From: Laura Gibbons
Sent: 11 July 2018 12:51
To: Anita Gardner
Subject: RE: M/64/18/DOC172 Elmer Road

Engineers Responses Relating to Condition 7- surface water drainage

Project:	172 Elmer Road	Date:	July 2018	Made by:	KS	Sheet No.	1
CALCULATION SHEET		Job No.	1735	Chkd:	-	Rev.	C

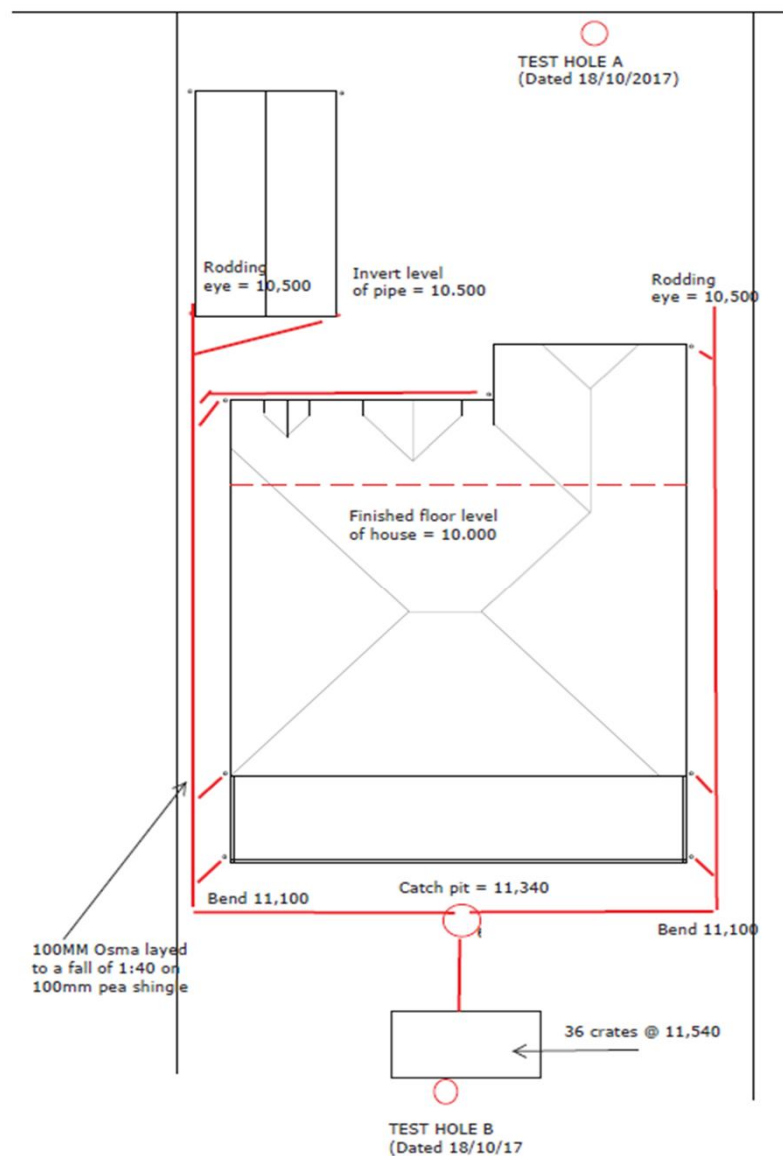
- I am a little confused as to how the infiltration rates have changed between submissions. In the previous submission the lowest rate was $6.07 \times 10^{-6} \text{ms}^{-1}$. Now it has changed to $5.46 \times 10^{-5} \text{ms}^{-1}$. Please can the applicant explain this discrepancy?
The original infiltration rate was incorrectly calculated and based on a different field test. The actual test was a percolation test with the results reported in Vp (mm/sec), the test method and the derivation of infiltration rate is detailed in the calculation together with the test results. And the worst infiltration value has been used which is very conservative as the infiltration rate measured at the location of the soakaway is an order of magnitude greater.

- The finished floor levels are labelled as being lower than the pipe invert levels. It is not clear if some of the levels on the plan are cover or invert levels. If all pipe levels are invert levels they need to reassess design, as water does not flow up hill. If they are cover levels then I am also concerned as the building finished floor level is 1.54 meters lower. Please can the application confirm the levels.
Our error. We went up with the figures (which is what happens when you read the measurements on site), rather than down for the plan.

- Manholes need to be provided at the corners of the property where there is a 90 degree change in pipe direction.
 - The winter groundwater monitoring was completed in October, therefore not at the peak of groundwater levels. As a result the base of infiltration structures need to be set no lower than 1mbgl.

- Please ensure all infiltration structures are at least 5m from buildings.
- We have now re-designed the drainage to account for all four above points. Please see attached.

Hi Anita,
I am happy with the revised details. My only comment is the applicant needs to ensure 150mm concrete bed and surround on all pipes.
Thanks,

Percolation test data supplied

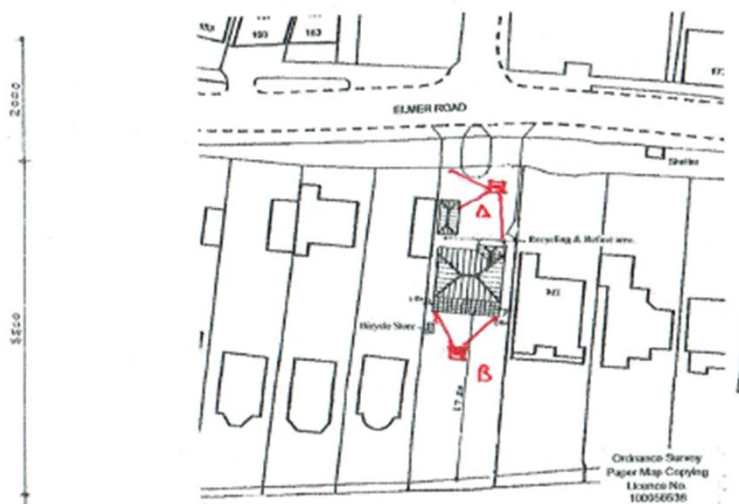
It should also be noted that the lowest recorded infiltration rate should be used, not the average. I.e. please use $6.07 \times 10^{-6} \text{ms}^{-1}$

It should also be noted that the lowest recorded infiltration rate should be used, not the average. I.e. please use $6.07 \times 10^{-6} \text{ms}^{-1}$ – Test hole A has the lowest infiltration level. This result has been used for the new calcs.
